Office of
Environment
& Heritage

Reference is made to your correspondence to the Office of Environment and Heritage (OEH) dated 31 October 2014, regarding the public exhibition of the Wahroonga Adventist School, Wahroonga (SSD 5535).

Office of Environment and Heritage comment on Wahroonga Adventist School, Wahroonga (SSD 5535).

Figure 9 – Site Plan of proposed Adventist Schooling showing setbacks to bushfire prone vegetation.

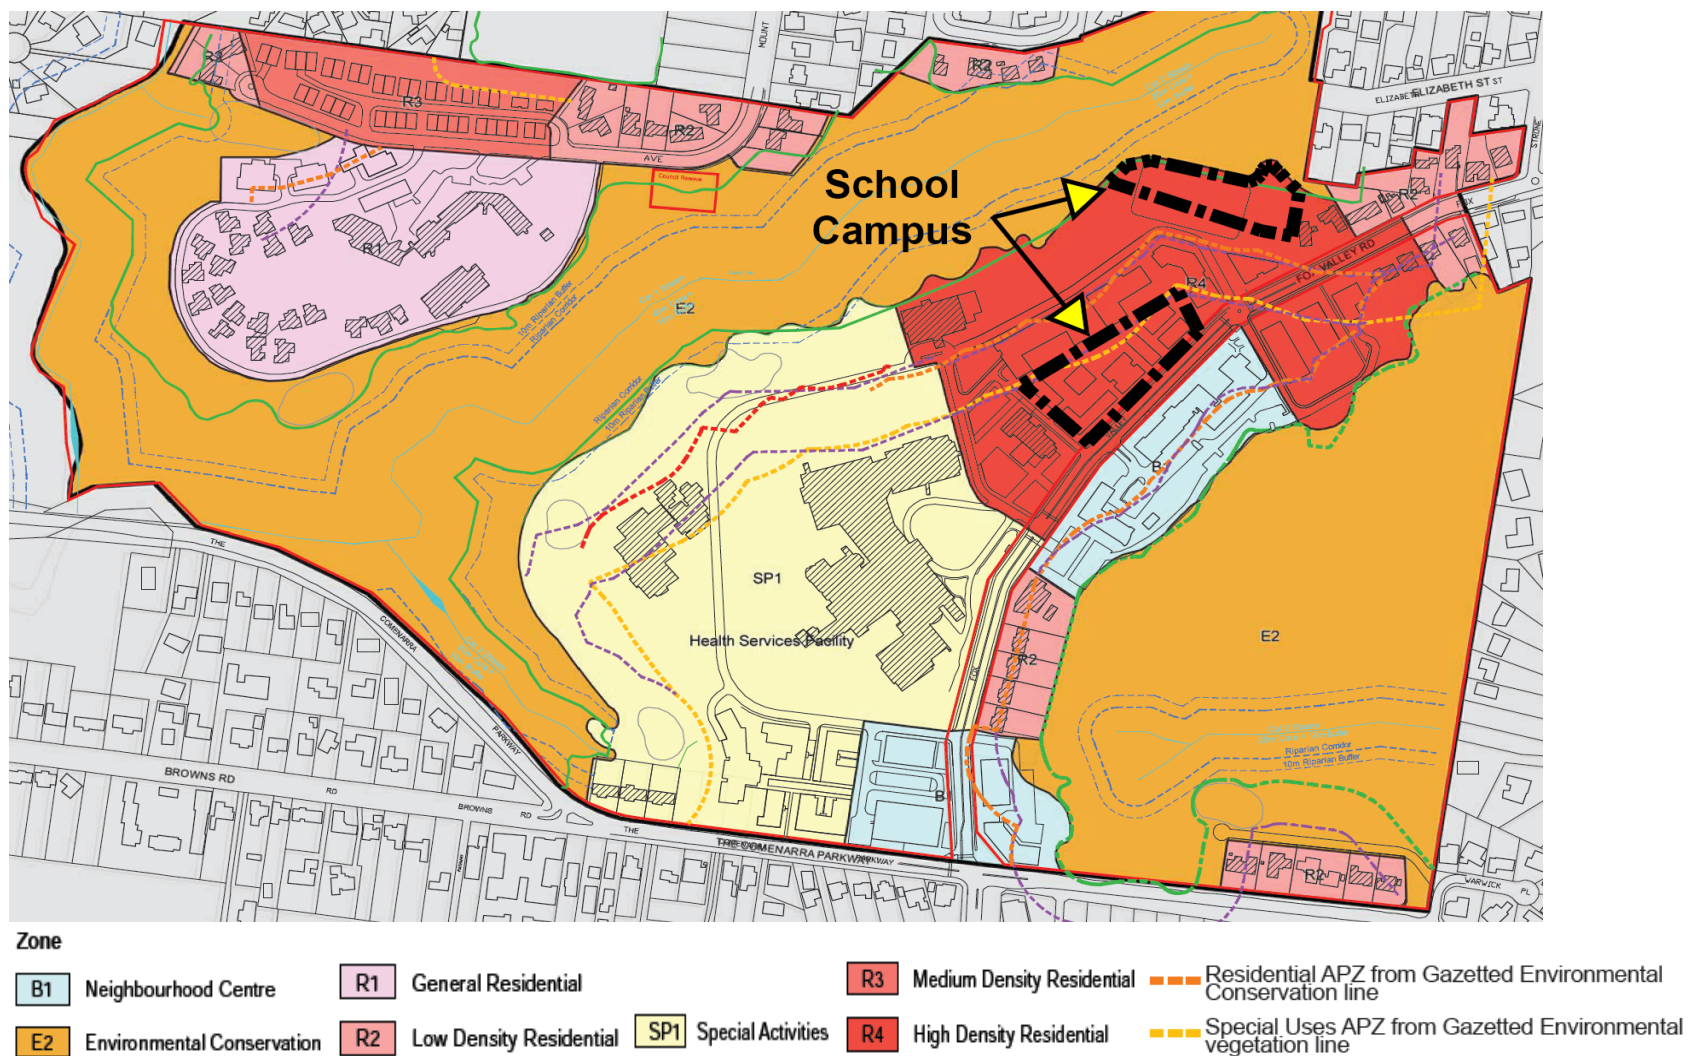
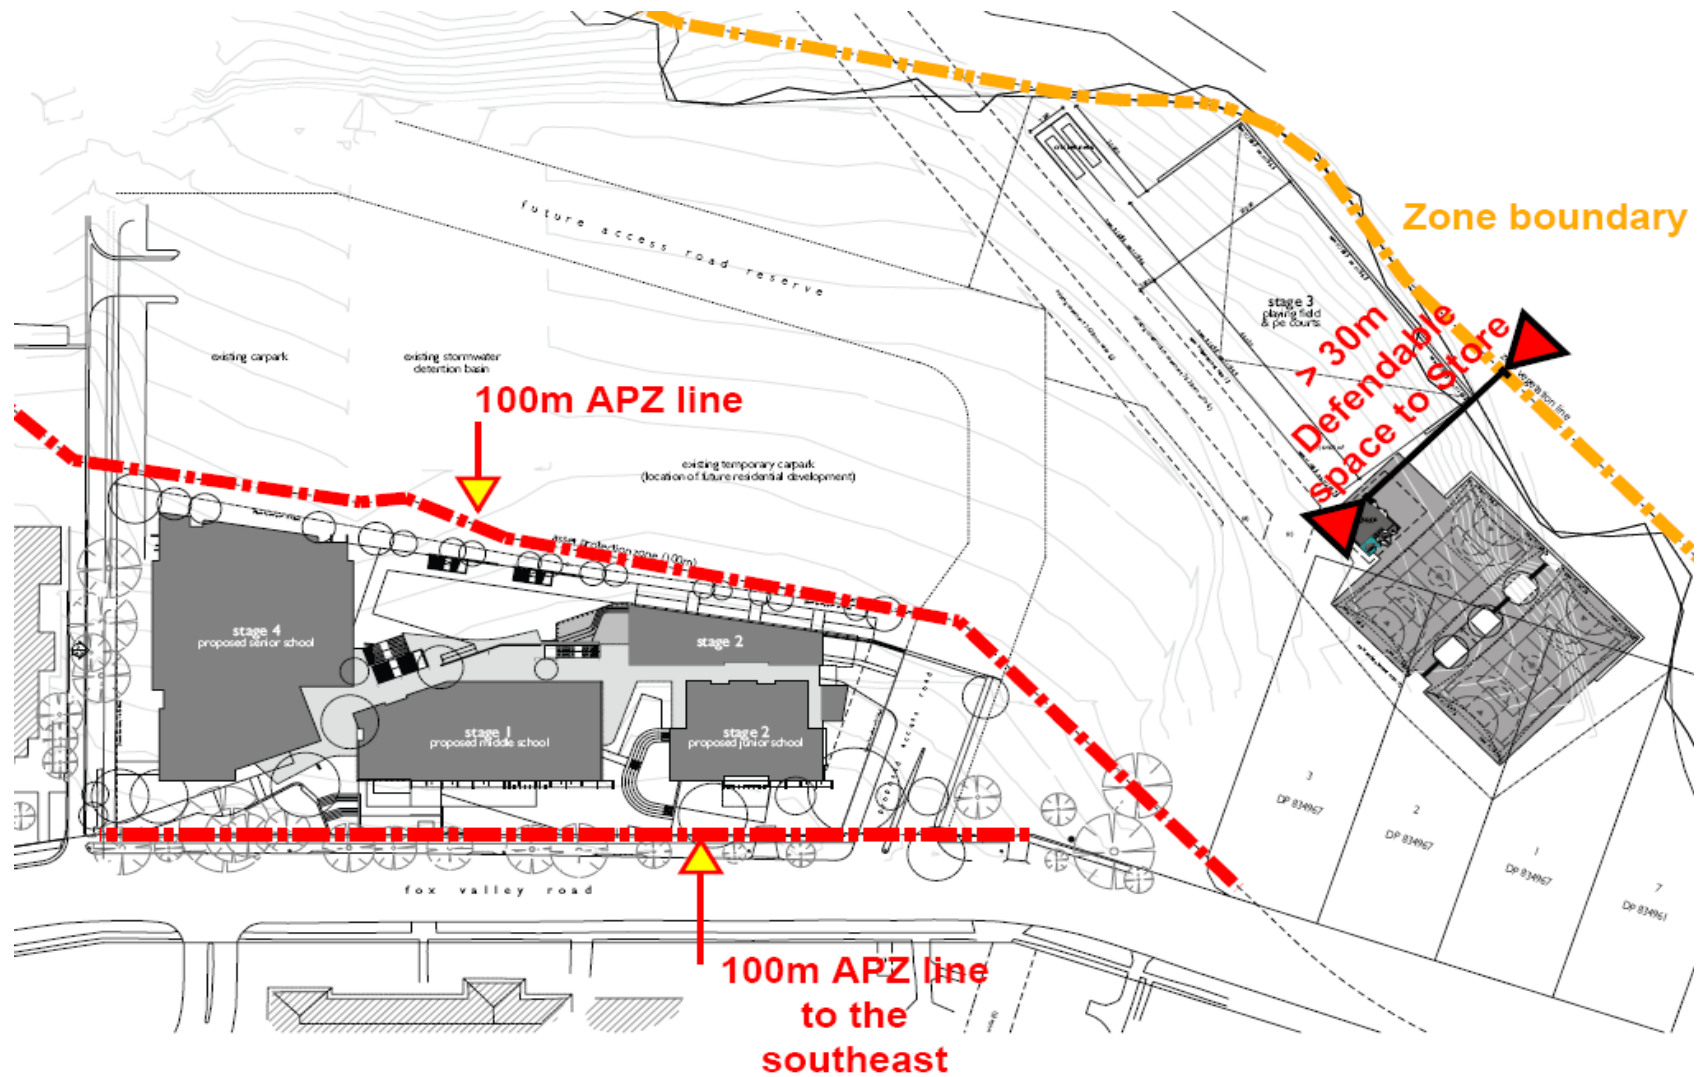
The Stage 3 - Playing Field and PE Courts is proposed to be located on the new site boundary to the E2 land with the retaining wall actually on the site boundary at its easternmost and westernmost ends. The playing field will require a retaining wall almost 3 metres above natural ground level.

OEH considers a setback for the playing field and PE courts to the E2 zoned land is required, and suggests this be a minimum of 3 metres. This would ensure that development impacts are entirely outside the E2 zoned land and that an adequate maintenance edge can be provided to the bushland area. In addition, there should be no use of machinery or stockpiling of materials within the E2 zoned area.
